ARBORIST REPORT

January 8, 2022

9017 Se 60th St.
Mercer Island, WA

You have asked me to prepare a written report that addresses those items detailed in the Intake Comments from City arborist John Kenney. This written report refers to a Tree Inventory and Assessment spreadsheet, which was submitted to you earlier. You have provided a Site Plan Sheet 'S' dated 12/9/ 2021.

CONTRACT  
 SITE PLAN  
 9017 SE 60th St

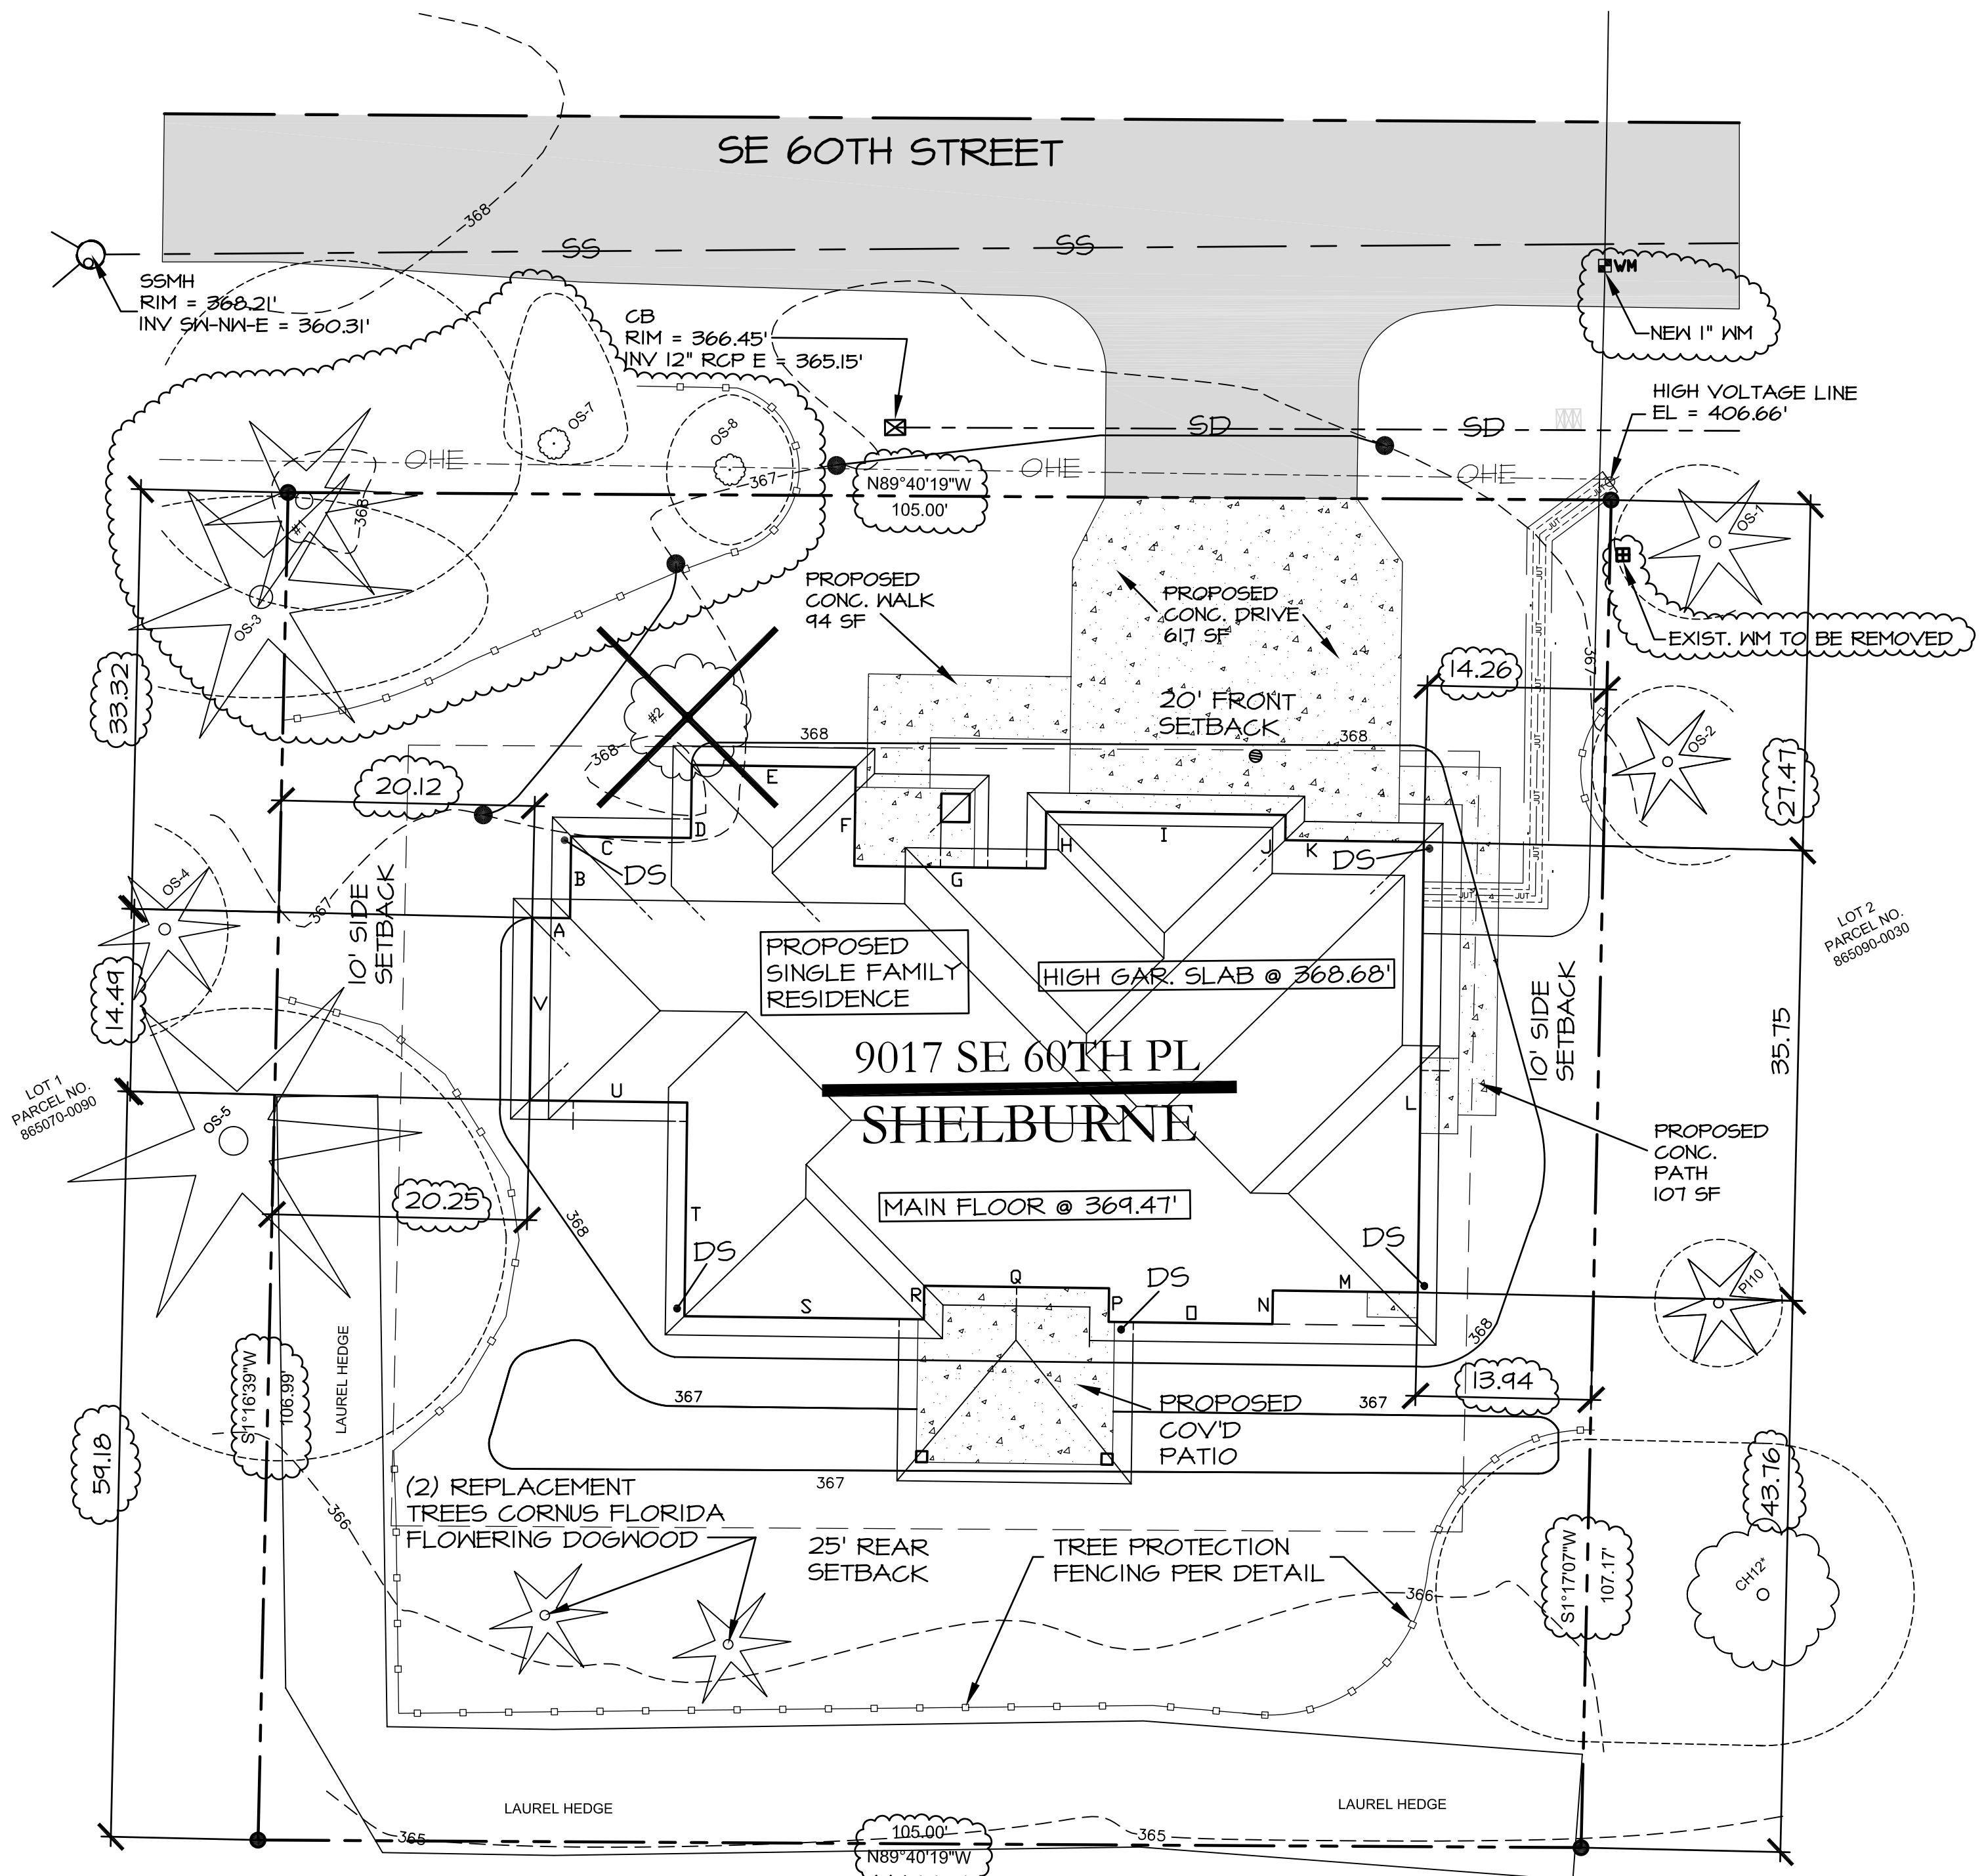
Tree #1 is a 21.6" DBH Douglas fir located in the very NW corner of the parcel. This tree will be retained, it's root system will be protected by 6' tall chain link fencing, per Mercer Island Tree Protection detail, which you have included on the above referenced Site Plan Sheet 'S'.

Site Plan Sheet 'S', referenced above, details the location of tree protection fencing for all of the trees. The following protective measures should be included on the above referenced site plan 'S', as well as on demolition or clearing/grading plan sheets.

- All of the protection fencing should be installed prior to any demolition work or other site work. Signage that explains the tree protection zone shall be installed as detailed on Plan Sheet 'S'.

- The installation of tree protection for Off-Site Tree #5 will be more involved in-so-much as the existing structure currently intrudes into the proposed tree protection zone. The tree protection for this tree should be initially installed as close to the existing structure as possible, while still leaving room for the demolition process.

- The removal of the existing concrete foundation in this area is likely to reveal roots from Tree #OS-5 right up against the foundation wall; every effort should be made not to damage these roots.

- Once the concrete is removed, the tree protection fence should be moved to provide for protection of any revealed roots.
- The removal of the concrete in this area, as well as the re-location of the tree protection fencing in this area should be completed under the supervision or monitoring of a tree professional.

I have reviewed Site Plan Sheet 'S' revised 12/9/2021. I believe the tree protection measures as detailed thereon, and as further detailed above in this written report, will provide adequate

protection for the trees. As stated prior in this report, the above bulleted items should be included on any demolition or clearing/grading plan sheets.
